The Secretary
NSW Planning, Industry & Environment

7 November 2021

I refer to the Department's below email of 4 November 2021 regarding the Environmental Impact Statement (EIS) for State Significant Development SSD-17552047 155-217 Aldington Road Estate for 'Development of a warehouse and logistics hub including construction and operation of two warehouses connected by a breezeway and comprising 64,260 m² of floor space as well as a 9-lot Torrens Title Subdivision' located at 155-217 Aldington Road, Kemps Creek (Lot 33 DP 258949 and Lots 25-28 DP 255560) in the Penrith City Council Local Government Area (LGA). Submissions need to be made to the Department by 2 December 2021.

1 ESTATE PLAN  
1:1500 @ A1

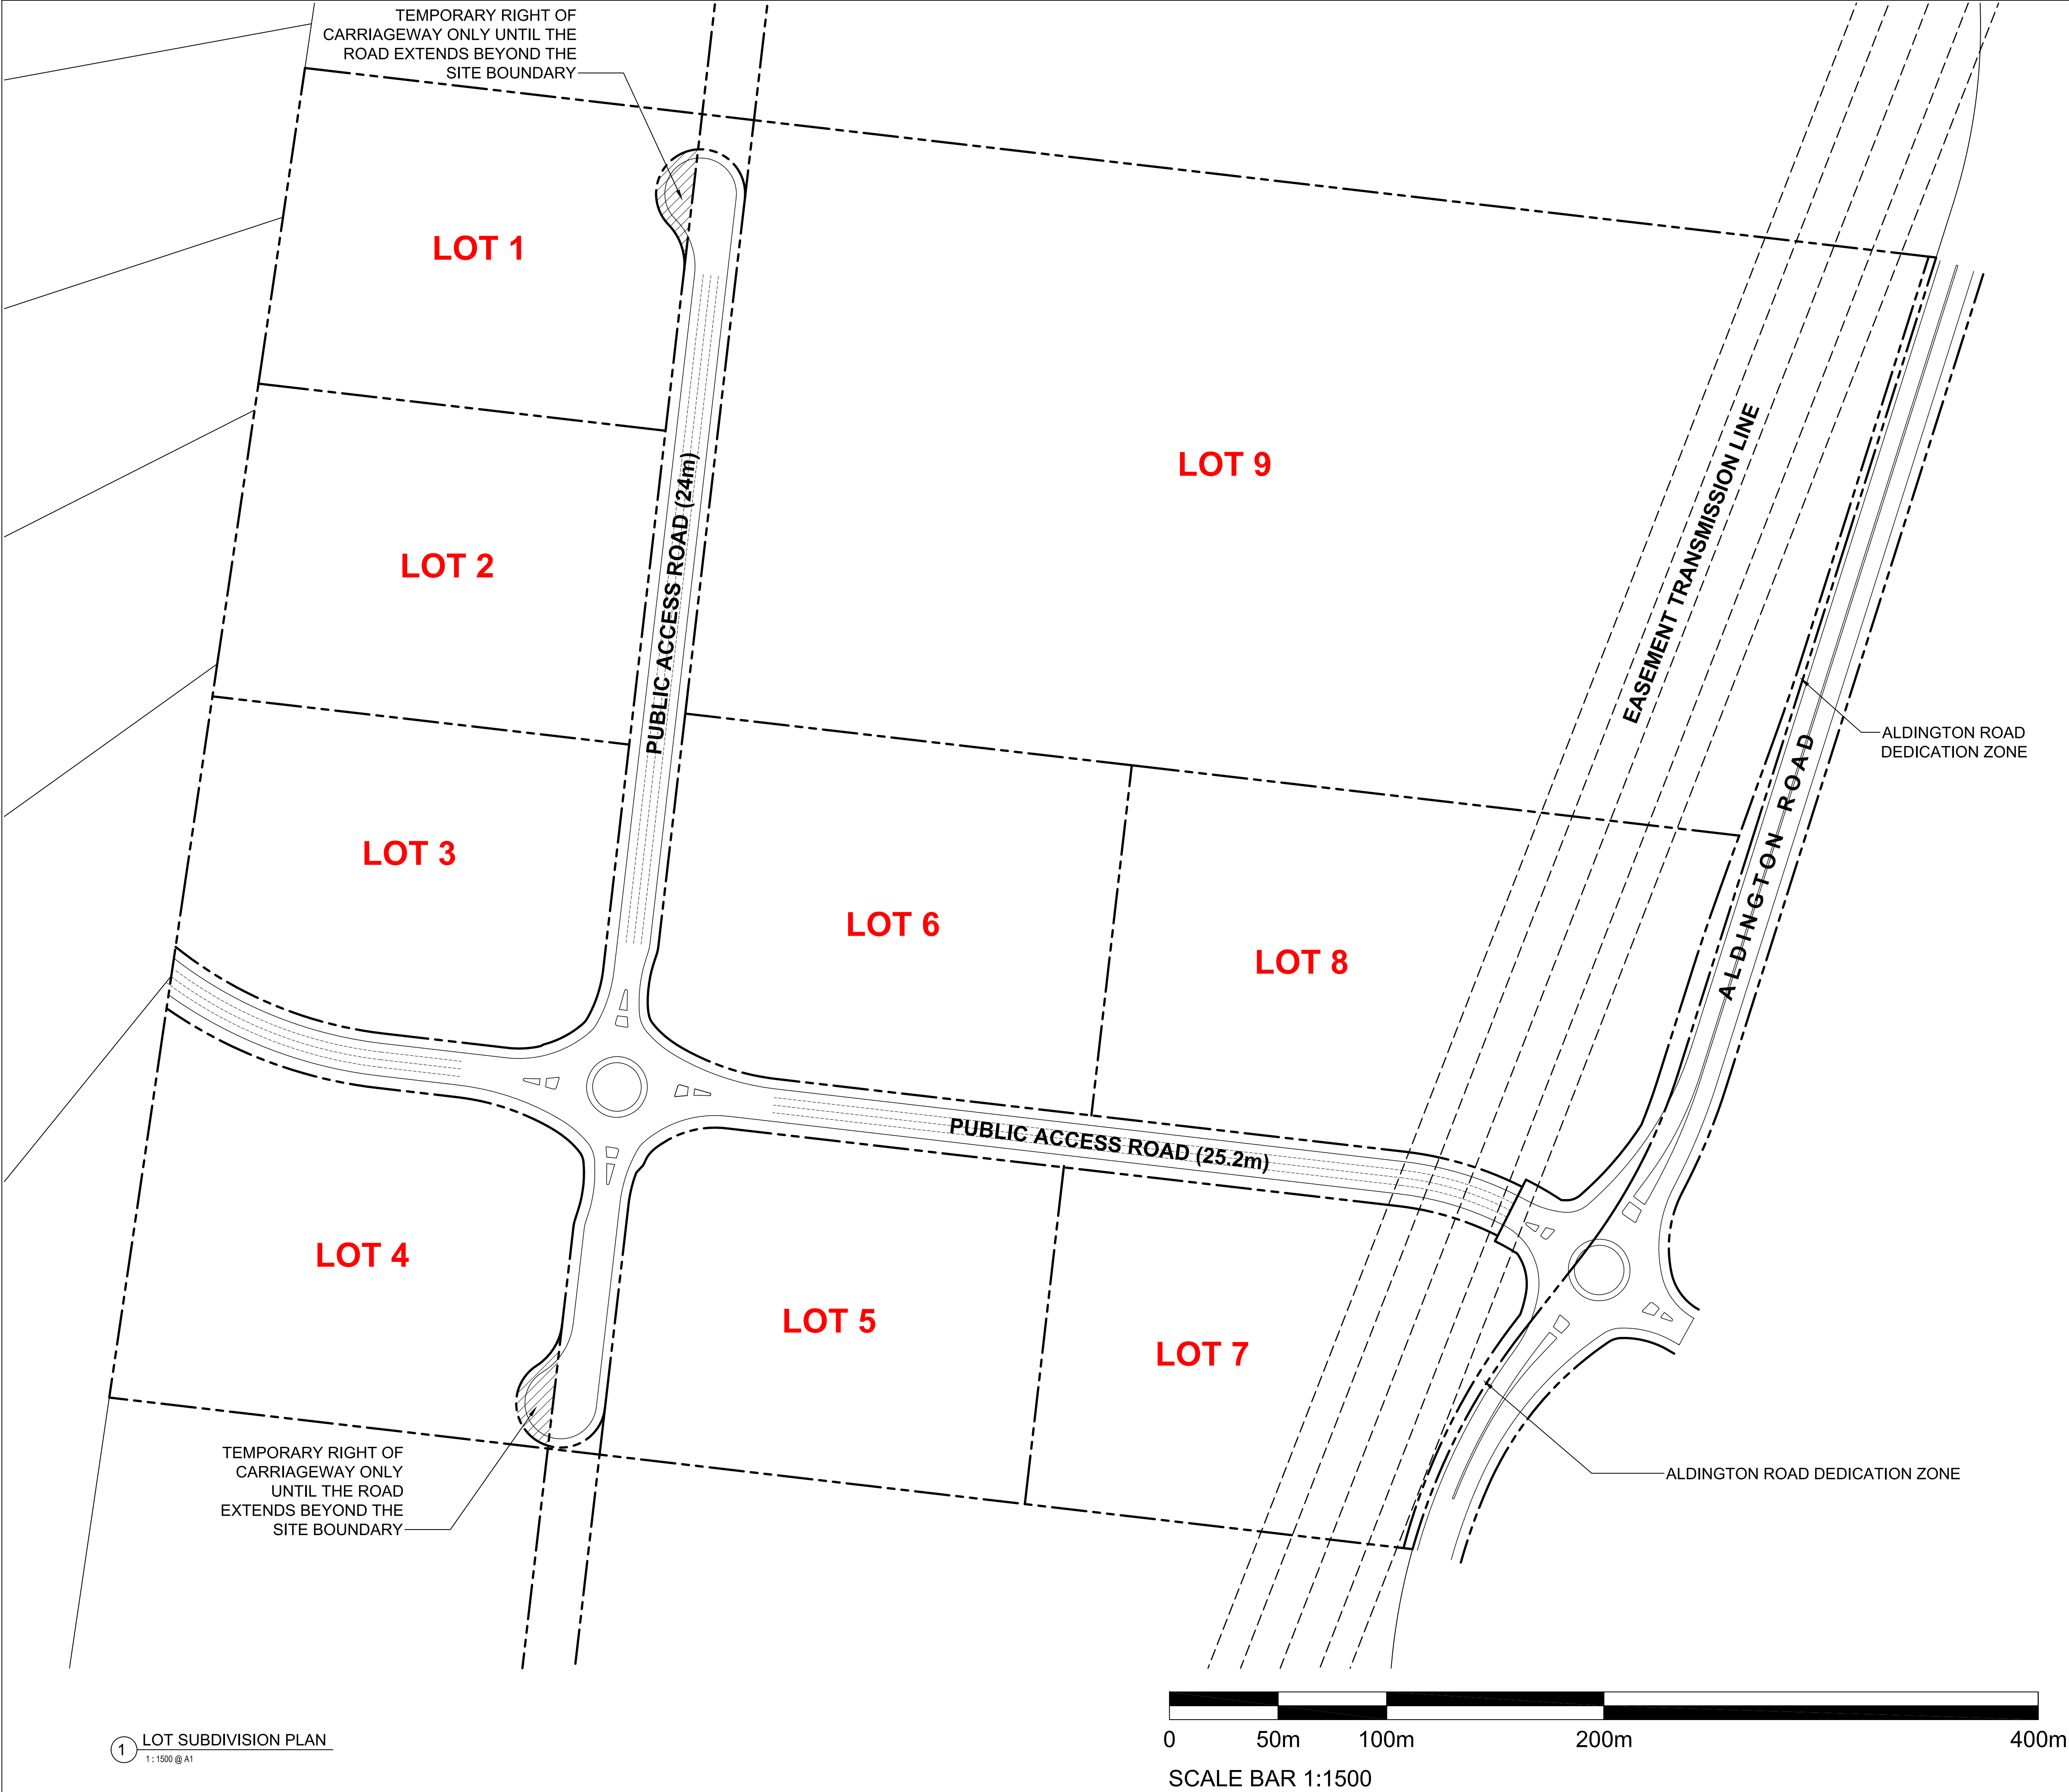
From the Architectural Plans it does not appear any provision has been made for a padmount substations required for the two warehouses.

Irrespective of the class / division and the quantities, any dangerous goods whether combustible and / or flammable should not be stored near electricity infrastructure and increasing the separation distance as far as reasonably possible is recommended ie. the padmount substations required to facilitate the proposed development should not be located near the Flammable Liquid Stores.
